From: Graham Nicolls [REDACTED]
Sent: 11 August 2021 10:46
To: Kathryn Welch <Kathryn.Welch@arun.gov.uk>
Subject: RE: 54 Tarrant street Arundel

From: Karine Suhrbier [REDACTED]
Sent: 19 April 2021 10:44
To: Conservation Officer <Conservation.Officer@arun.gov.uk>; Martyn White <Martyn.White@arun.gov.uk>; Andy Waite [REDACTED]
Subject: 54 Tarrant street Arundel

REAR ELEVATION - CHIMNEY AND WINDOWS 6, 7, 10 + 11

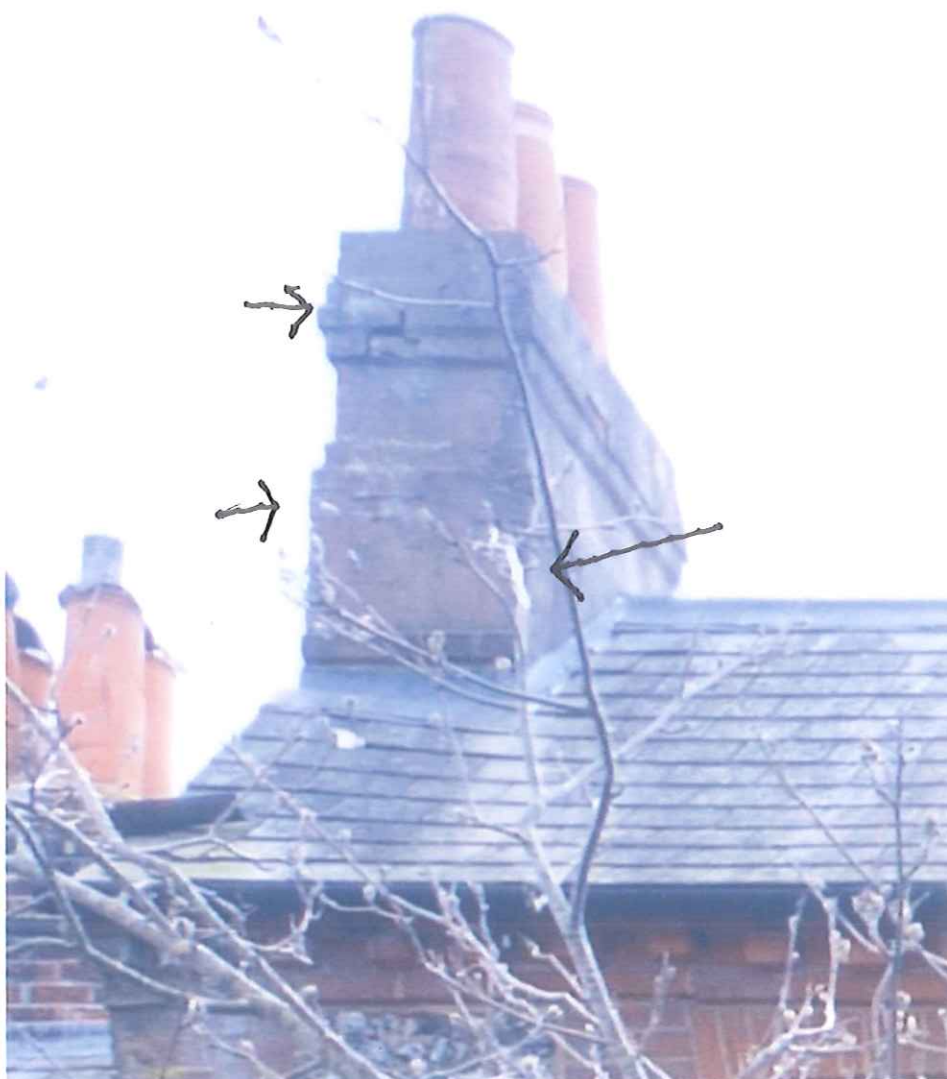
We have noticed for some time that one of our chimneys has needed some attention, and we have just had someone who specialises in this area, tell us that it needs taking down and replacing. So this is another thing I appreciate your thoughts on, is if we can just go ahead, as it is essentially a repair and all will be replaced like for like, or if we need to go for planning consent, or if we need full planning permission?

3. We have noticed for some time that one of our chimneys has needed some attention, and we have just had someone who specialises in this area, tell us that it needs taking down and replacing.

So this is another thing I appreciate your thoughts on, is if we can just go ahead, as it is essentially a repair and all will be replaced like for like, or if we need to go for planning consent, or if we need full planning permission?

This will require Listed building consent, and as you state would have to be a like for like replacement i.e., in terms of the height, materials, appearance, detailing etc.

PROPOSED DETAIL FOR
 WINDOWS W6, W7, W8 + W9
 WHICH WILL BE DOUBLE GLAZED

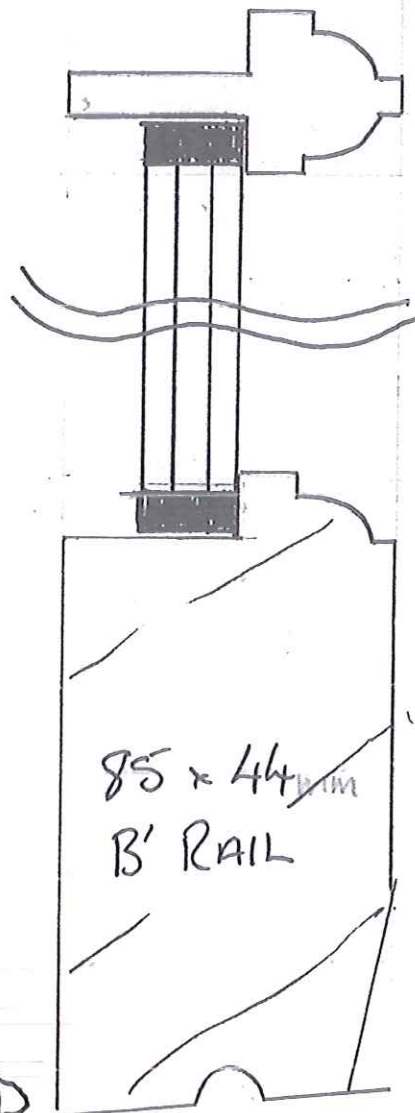
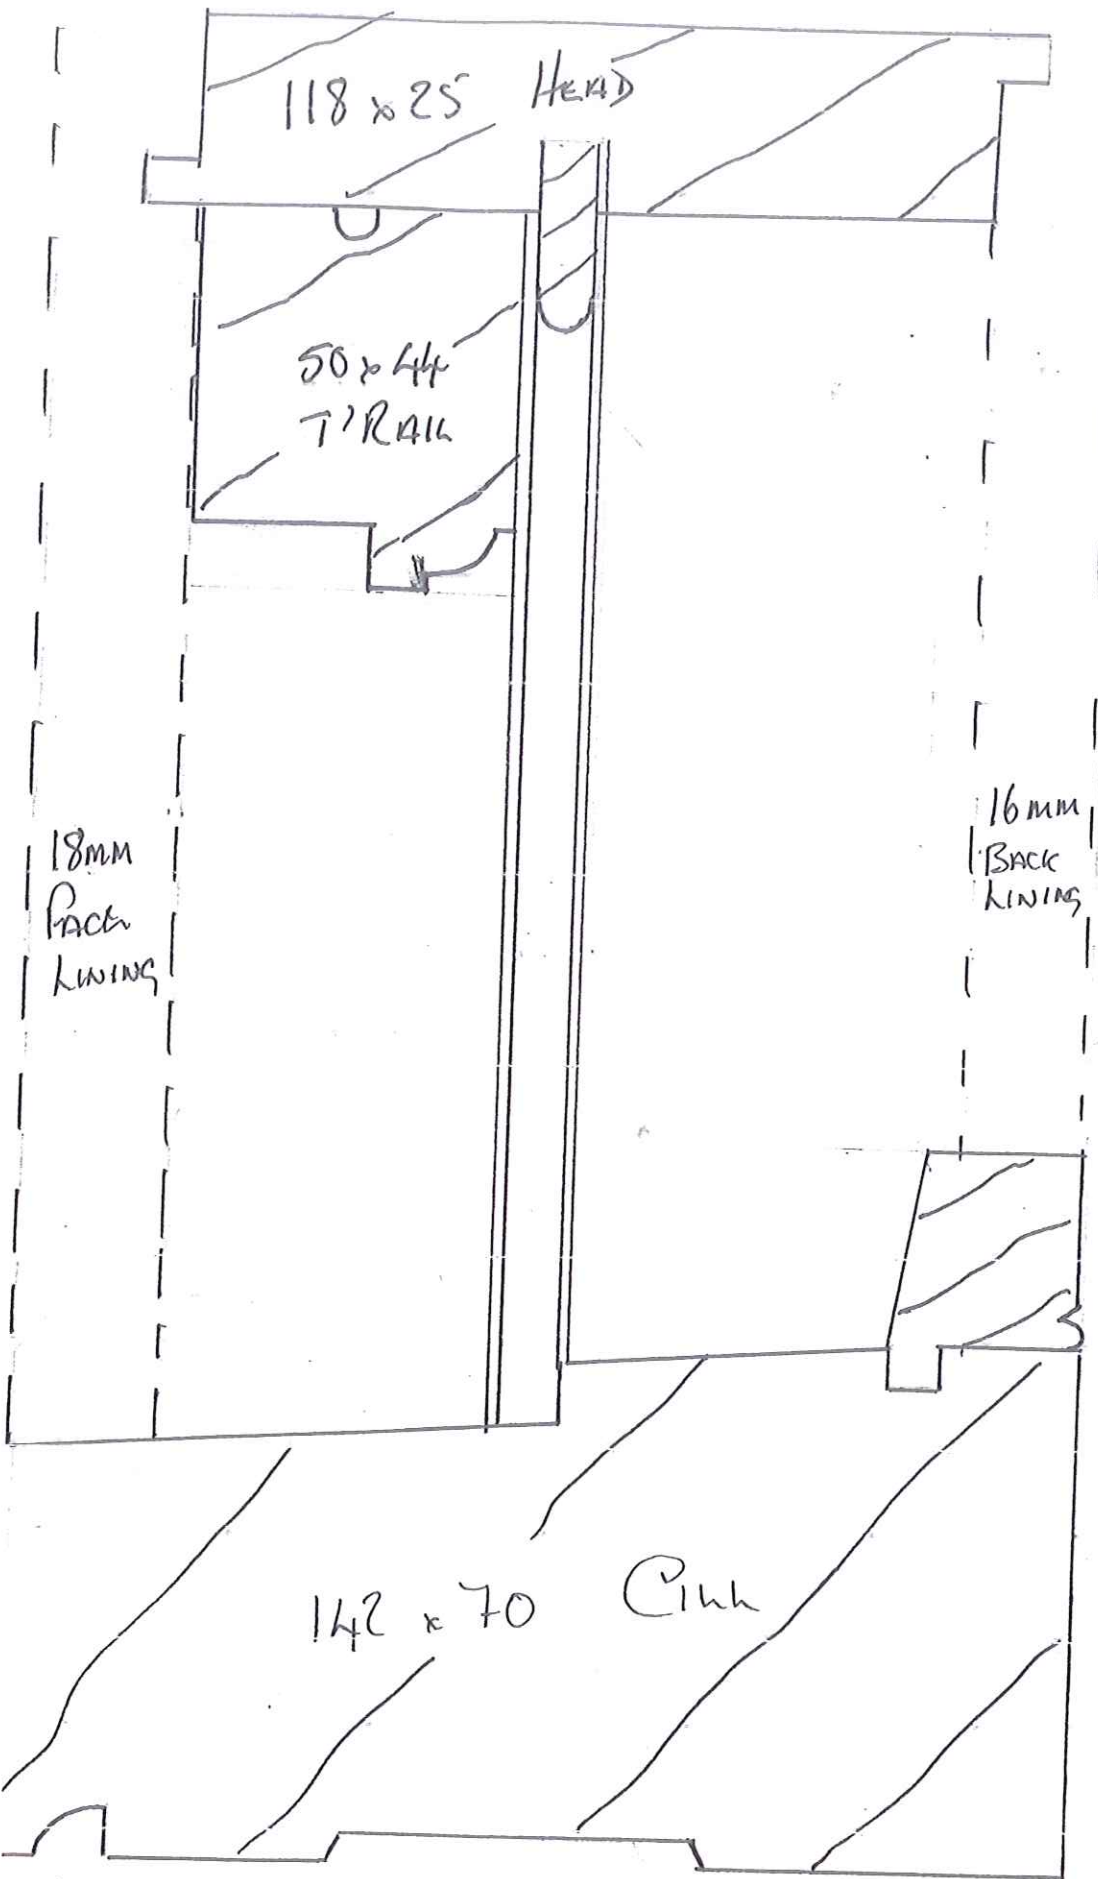
I wonder if you could give me your opinion on whether it is worth trying to get planning permission for double glazed units or if we should go for acoustic glass instead?

the glazing bars are 24mm x 44mm, and the windows will match the existing ones in all but that the new glazing bars are 2mm thicker than the old.

I have as yet not received any further communication about this. I wonder if you could give me your opinion on whether it is worth trying to get planning permission for them or if we should go for acoustic glass instead?

Double glazed units have been allowed in a limited number of properties in certain circumstances: the windows and the glazing were modern and did not affect the significance of the building. Ideally, the replacement windows would include single glazing as this is still best for the age and character of the listed building and area. However, as this proposal would only relate to the top floor, the impact would be lessened, and could be capable of support dependent upon the age of windows and the windows closely reflecting the existing, which I note you say would be the case.

REPLACEMENT, ALTERED + NEW WINDOWS  
54 TARRANT STREET, ARUNDEL

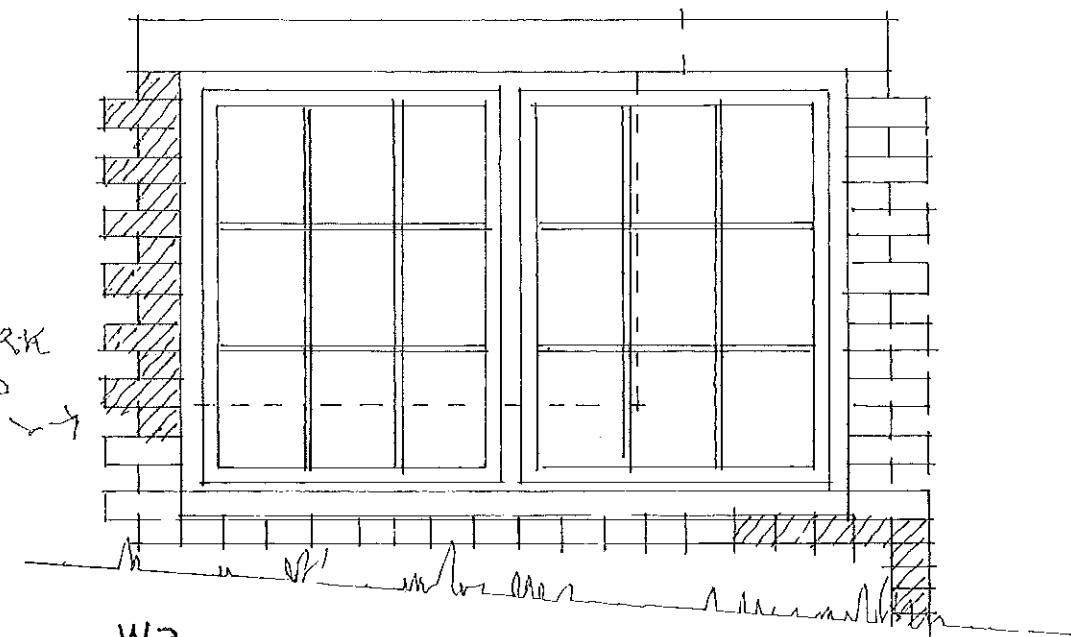
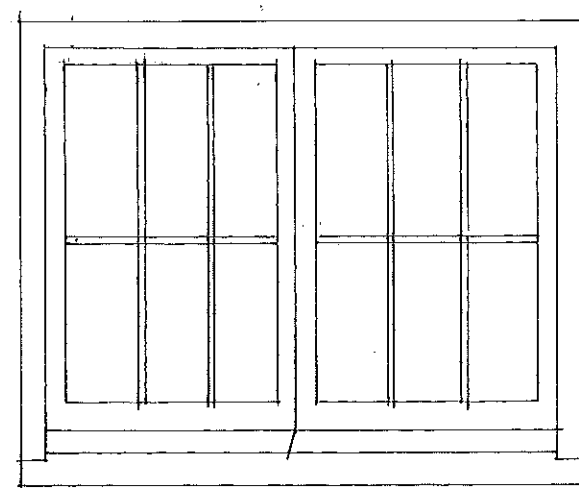
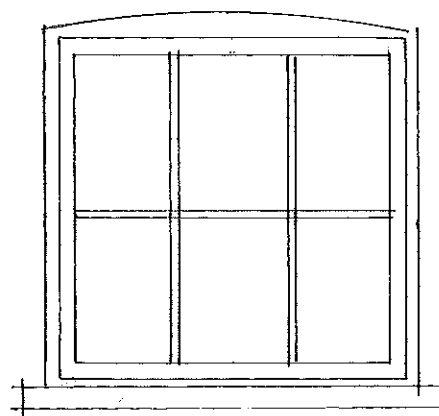
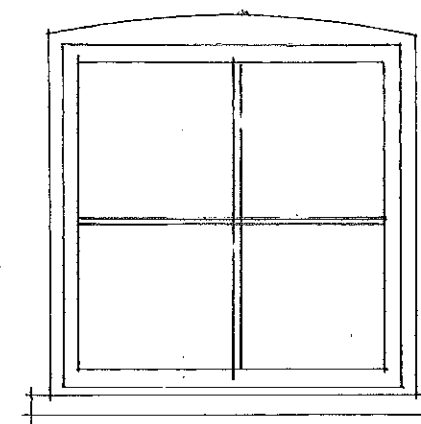
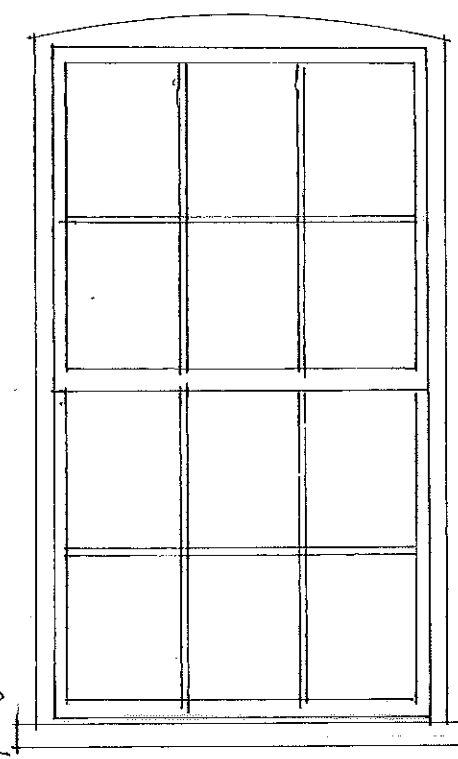
We also need to replace the two windows, the main window to the street, like for like, though using acoustic glass, and the side window from slatted to glazed and openable...design yet to be considered.

I would also state that if you were to replace the two basement windows (the main window to the street, like for like, though using acoustic glass, and replace the side window from slatted to glazed and openable), you would also need to apply for listed building consent, but this would be acceptable.
